Recommendation Report for Planning Permission

REF NO: LU/297/19/PL

LOCATION: Land to rear of
141 Wick Street
Littlehampton
BN17 7JY

PROPOSAL: 1 No. new dwelling (resubmission following LU/84/19/PL).

Rev:	
 23 Mill Road Angmering, West Sussex BN16 4HT E:natdesign1@gmail.com	
Project: Land to the rear of 141 Wick Street Littlehampton West Sussex BN17 7JY	
Drawing Proposed Elevations	
Drawn By: NSE	Scale: as shown @ A3
Date: Sept 2019	Revision:
Drawing No. 458 - DPA 04

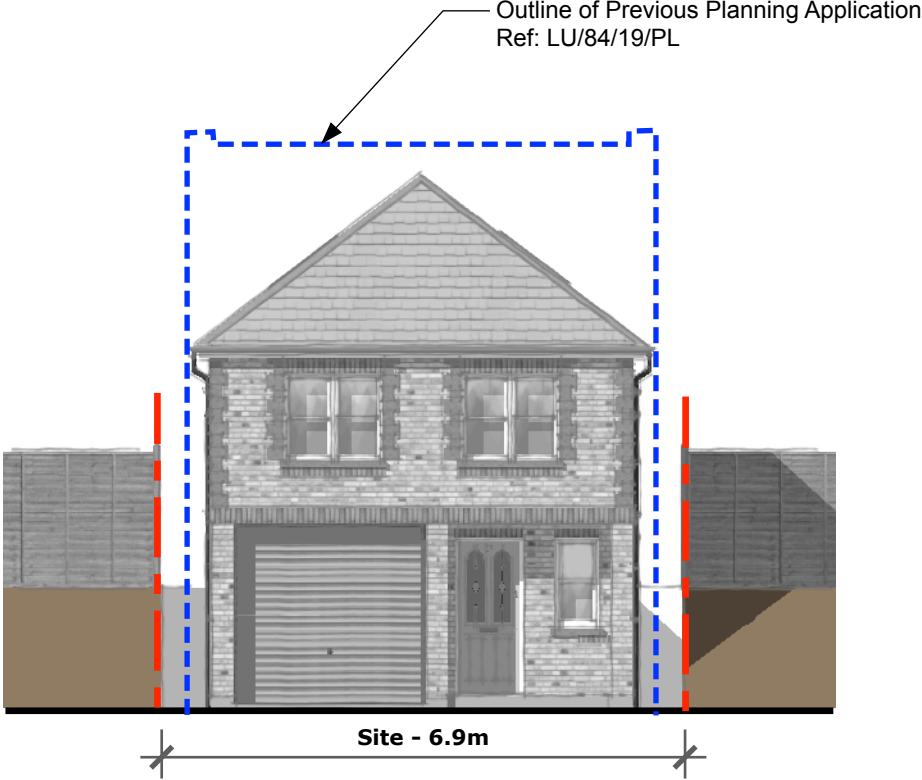
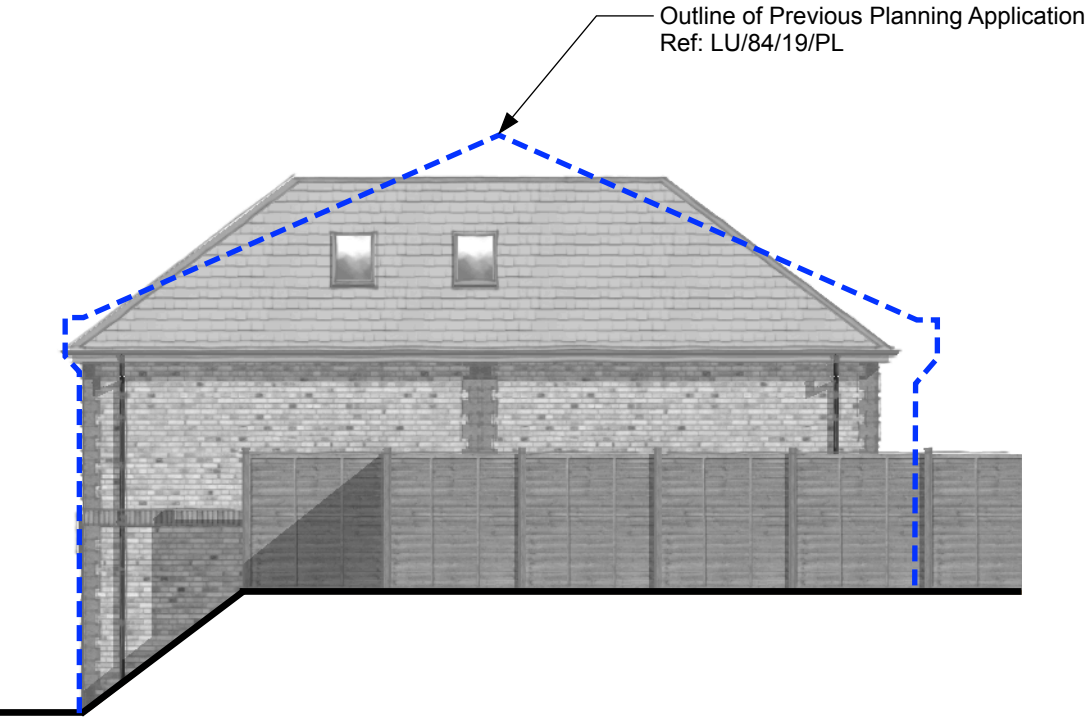
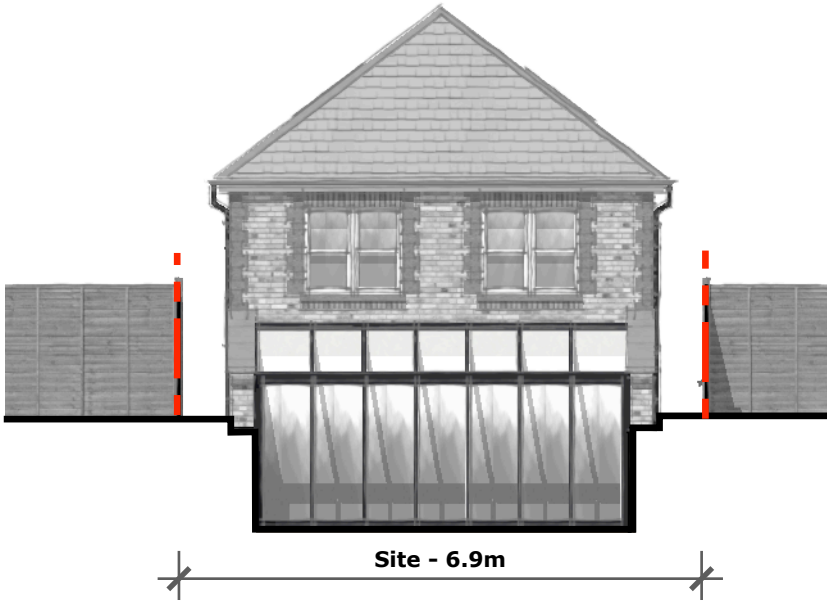
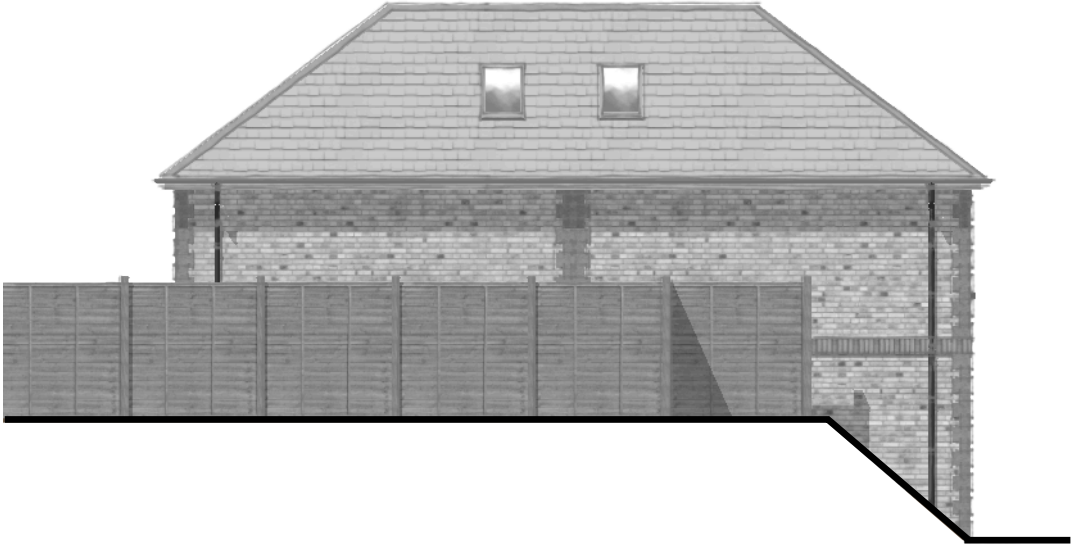
The proposed development is considered to have an unacceptable overbearing impact on the garden to the South of the application site. This is primarily due to the scale and the design of the proposed development. The dwelling would have an eaves height 3.1m from existing ground level of the application site, of which approximately 1.4m is visible over the boundary treatment of the garden to the South. Over a length of 10.5m, the proposed dwelling is considered to appear overbearing, and unneighbourly in its appearance. The site to the North is used as a parking area.

With regard to loss of privacy to neighbouring dwellings, the development does not give rise to any harmful overlooking of adjacent sites. There are no west facing windows and the windows on the Eastern elevation of the dwelling are sufficiently distant (approximately 21m) from the first floor windows serving the flat 141a Wick Street to the East. There is an open area of currently vacant land at ground floor level, which is not private amenity land, and is instead associated with the hairdressers at 141 Wick Street. Permission LU/16/17/PL, which allows for an extension to the commercial unit, with a parking space. To the West, North and South, the windows are rooflights, and do not provide any harmful views of neighbouring dwellings due to their height above the internal floor level.

- 2 The proposed development is considered to be located in very close proximity to the adjacent plot of amenity land to the South and thereby have an overbearing and unneighbourly impact on the users of this space in conflict with policies D DM1(3) of the Arun Local Plan, and policy 1 of the Littlehampton Neighbourhood Plan.

Section A-A
Scale 1:100 @ A3

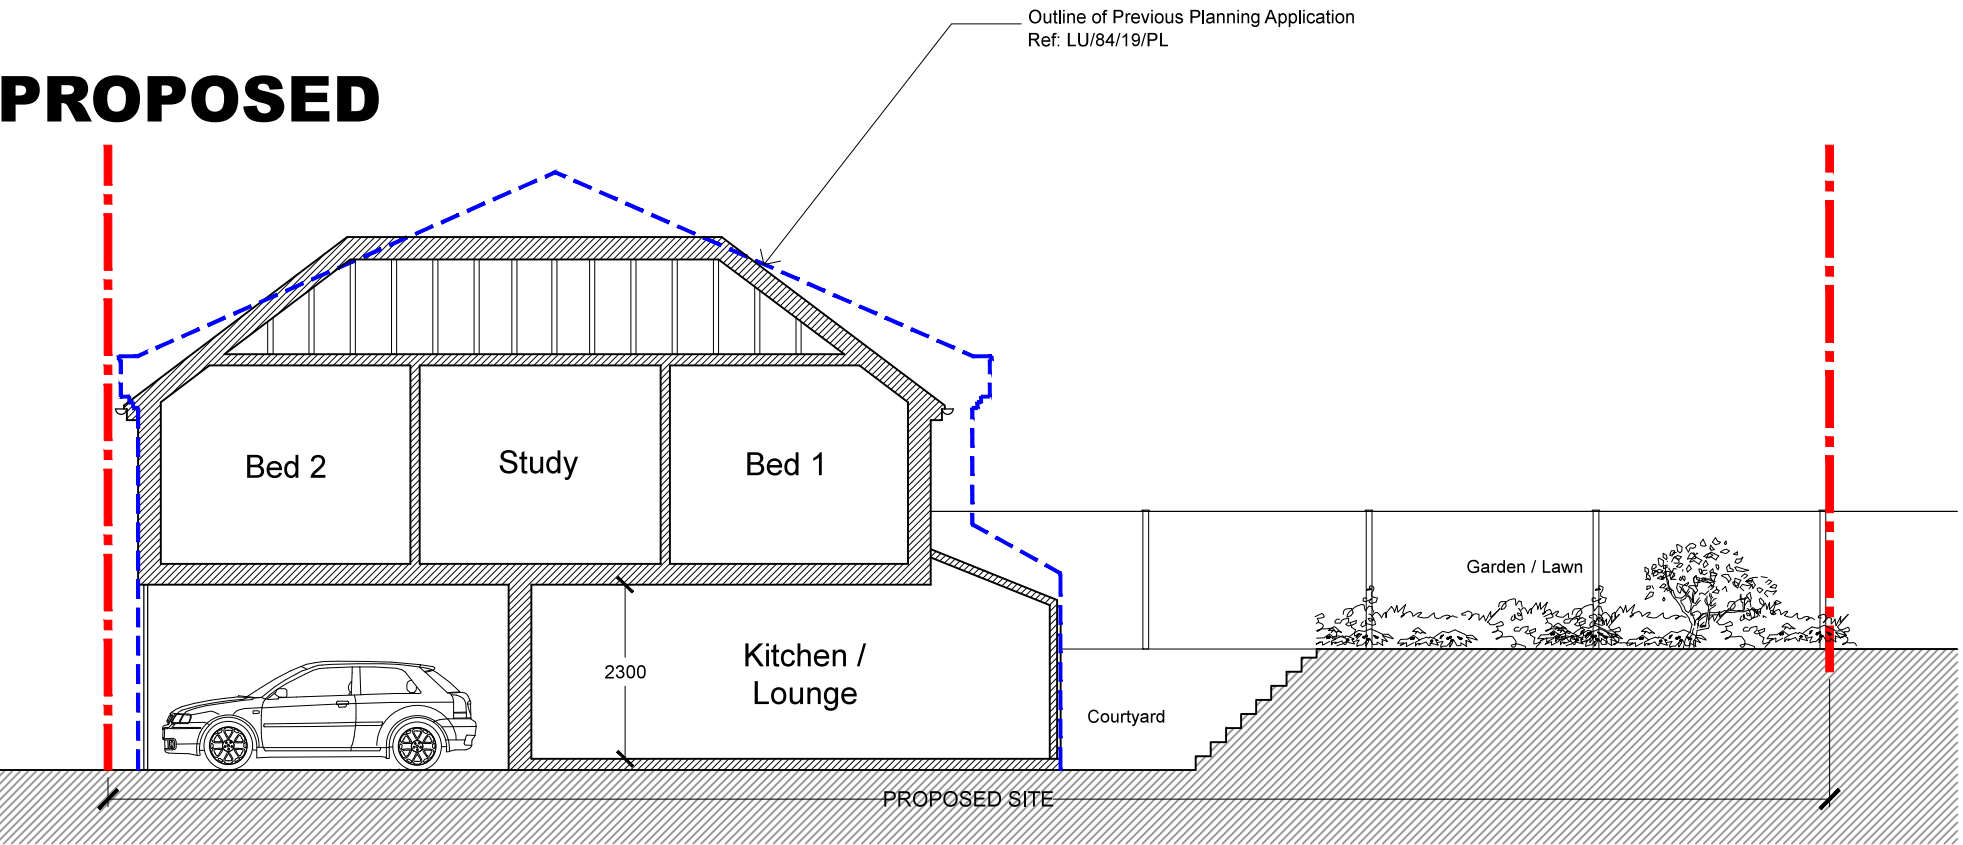
The position of the site and its size would result in development that is not in keeping with the general pattern and scale of development in the locality. The dwelling would be positioned close to the Northern and Southern boundaries of the site. The dwelling is sited approximately 0.7m from these Northern and Southern boundaries respectively, which although allows space for access to the rear (for bike storage), this constrains the proposed dwelling and looks visually at odds with the private amenity area to the South, and the open land to the North.

SITE PLAN
PROPOSED
1:100 @A3

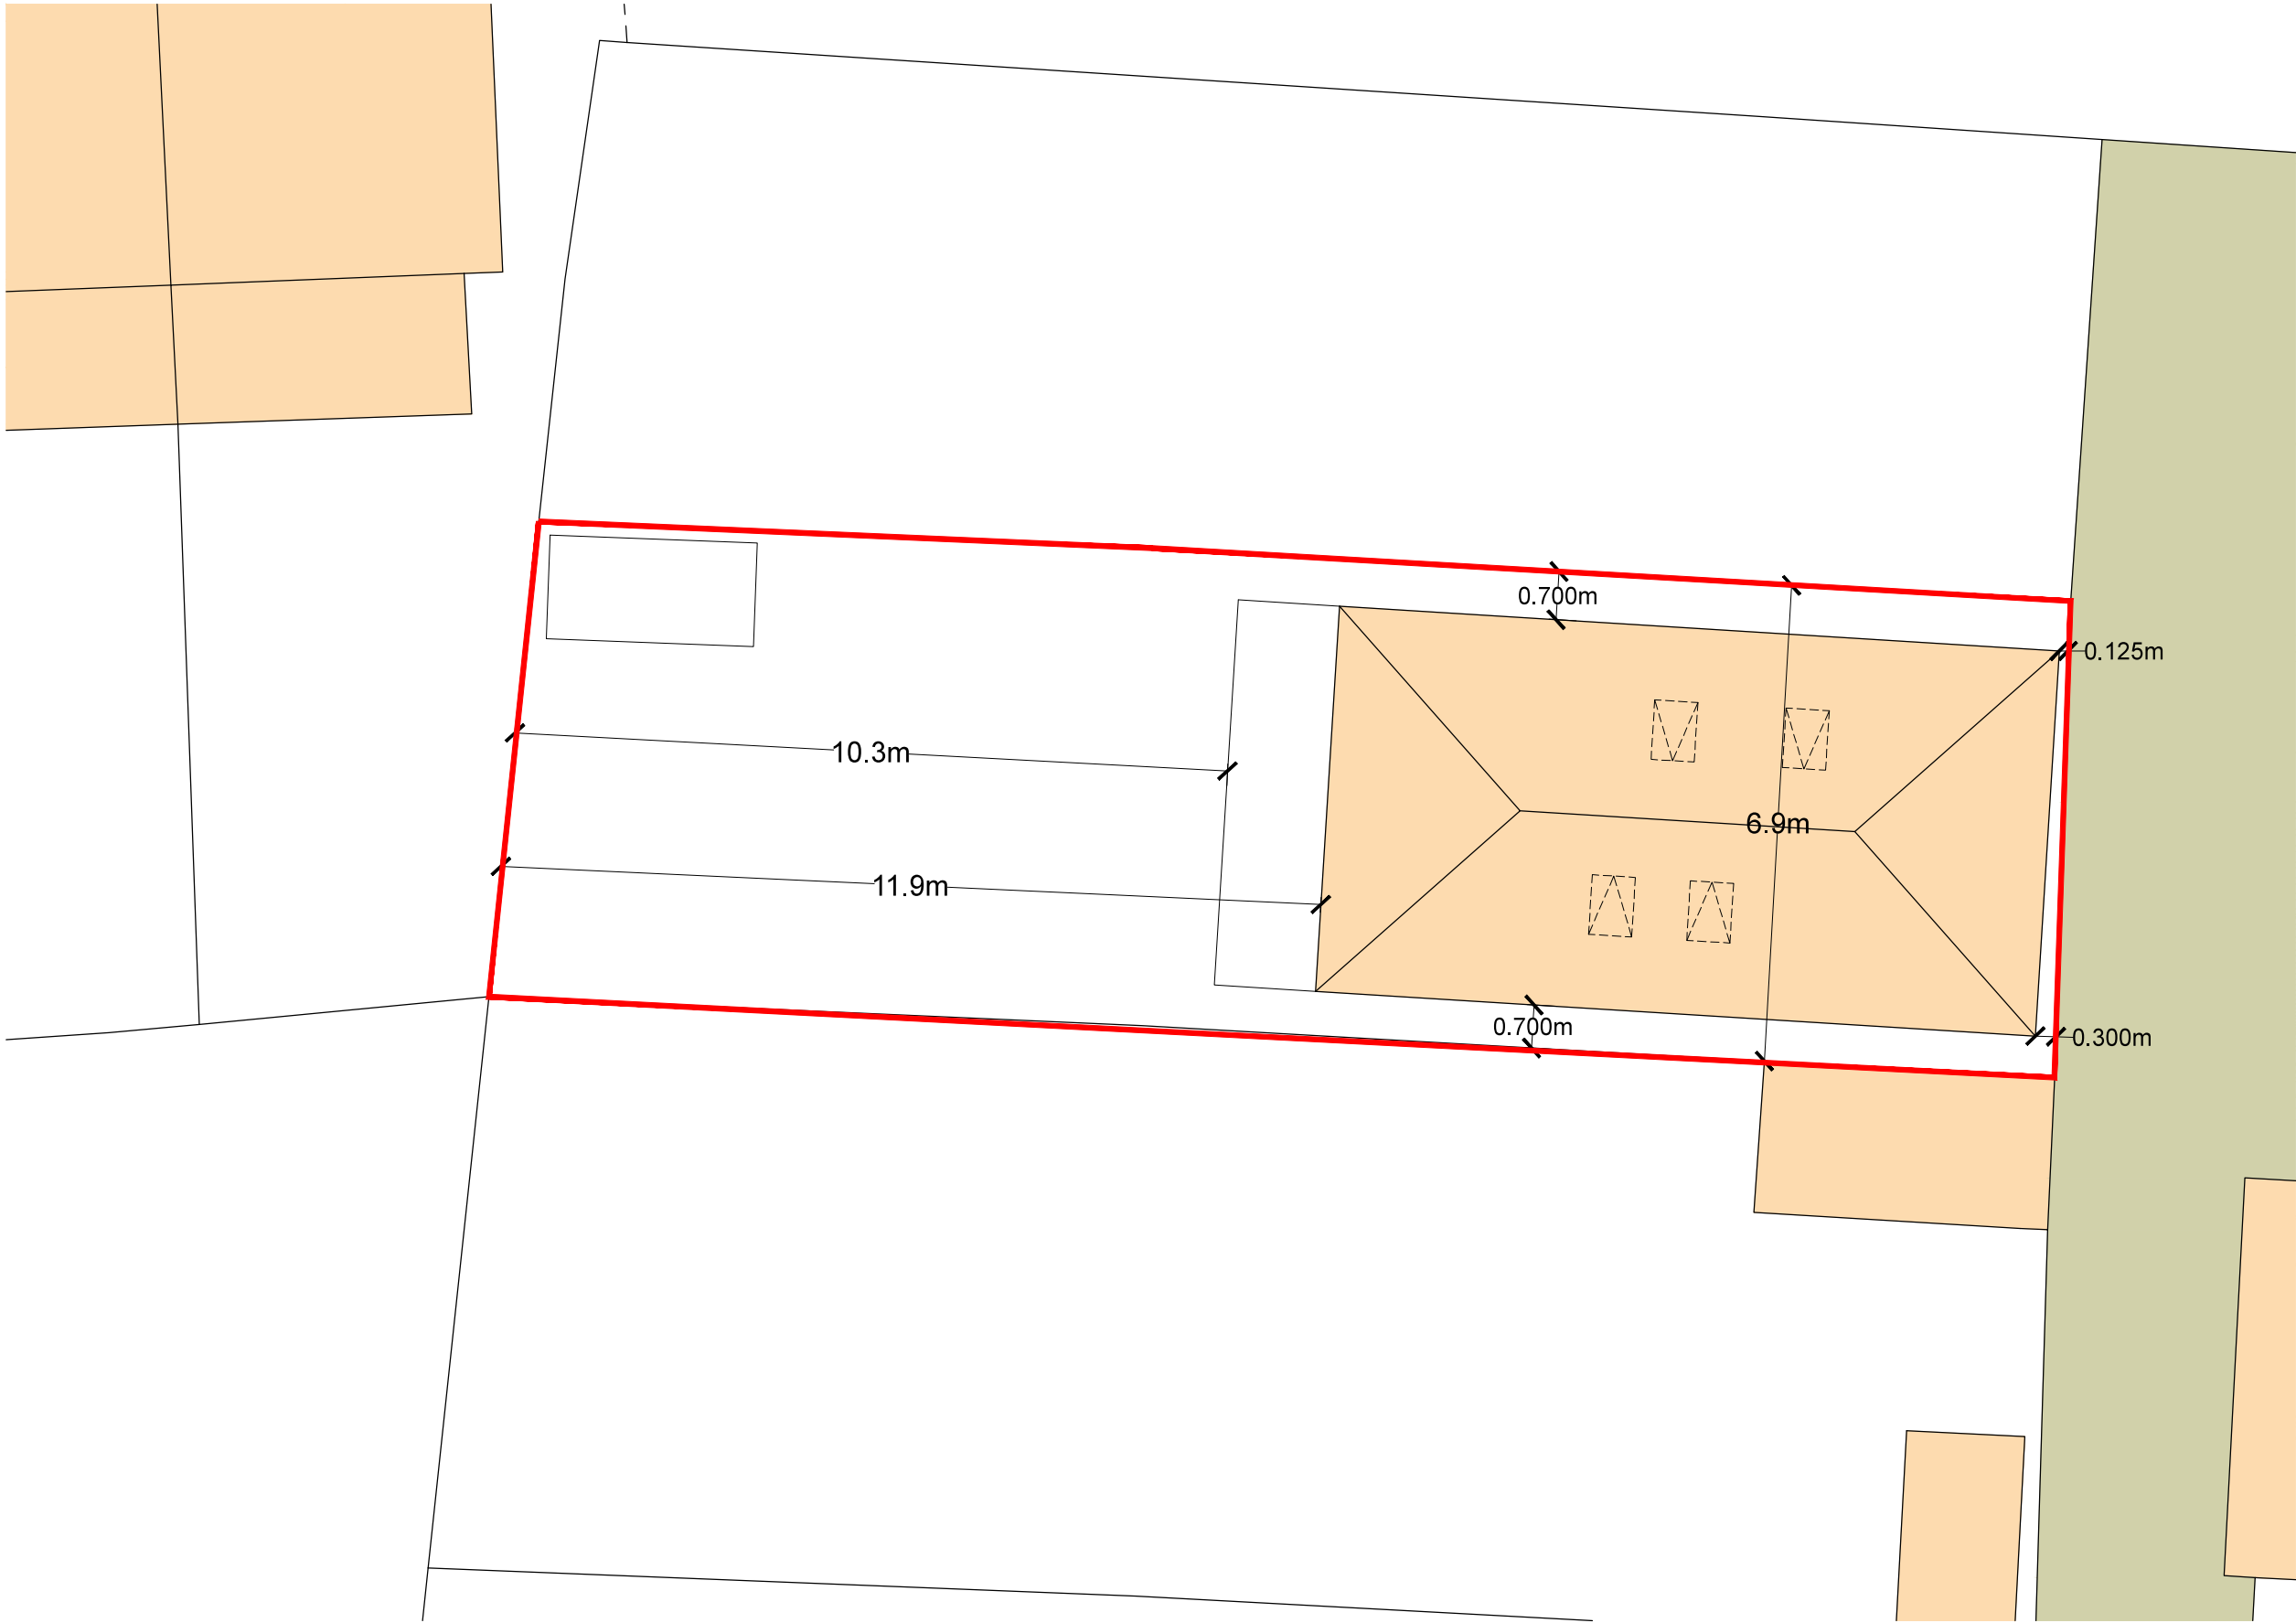
Having regard to the existing character and layout of the area, it is considered that the proposal would have a constrained and cramped appearance not in keeping with the established layout and pattern of development failing to integrate with its surroundings and thereby harming the character of the locality. The proposals would therefore conflict with policies D DM1 and D SP1 of the Arun Local Plan and policy 1 of the Littlehampton Town Neighbourhood Plan which requires development to be compliant with development plan policy which includes that development has an acceptable design and impact on occupiers of land/buildings and that it respond positively to the character of the area.

With reference to the Arun District Council Parking Standards SPD, the proposal is considered to meet these standards, in that there is an area East of the site provides space for two vehicles. The sites demand in this document is one car parking space for the development, and one visitor space.

- 1 The proposal would have the appearance of an unduly cramped form of development which would have an unacceptable impact on the established pattern of development in the locality in conflict with policies D DM1 and D SP1 of the Arun Local Plan and policy 1 of the Littlehampton Neighbourhood Plan.

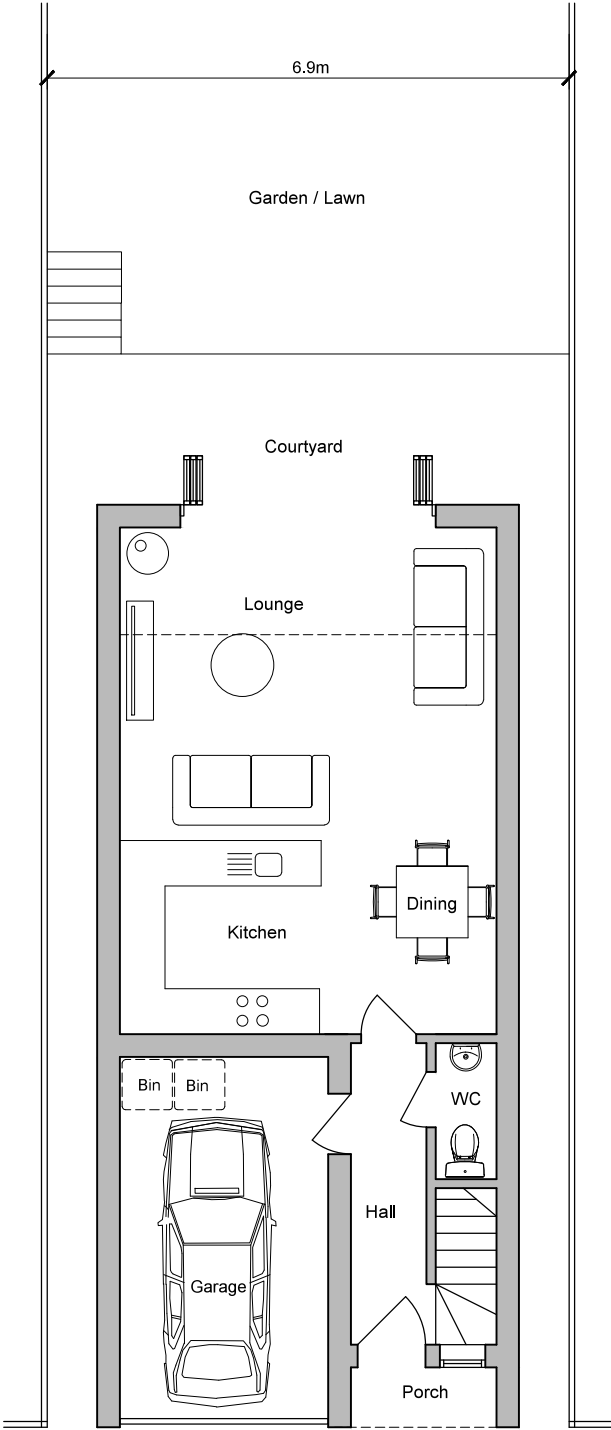
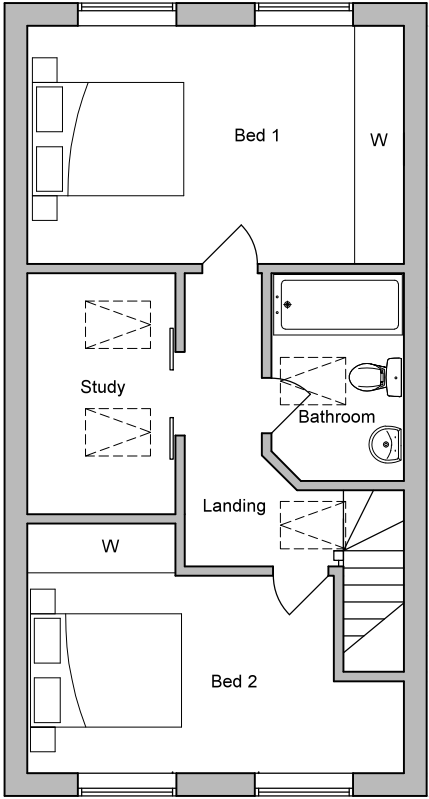
The dwelling has a floor area and an internal layout depicting; 2 storey, 2 bedroom, for 4 person occupation. The required space standard is 102m². The floor area, as stated in the Design and Access Statement is approximately 104m². Therefore, the dwelling accords with the standards.
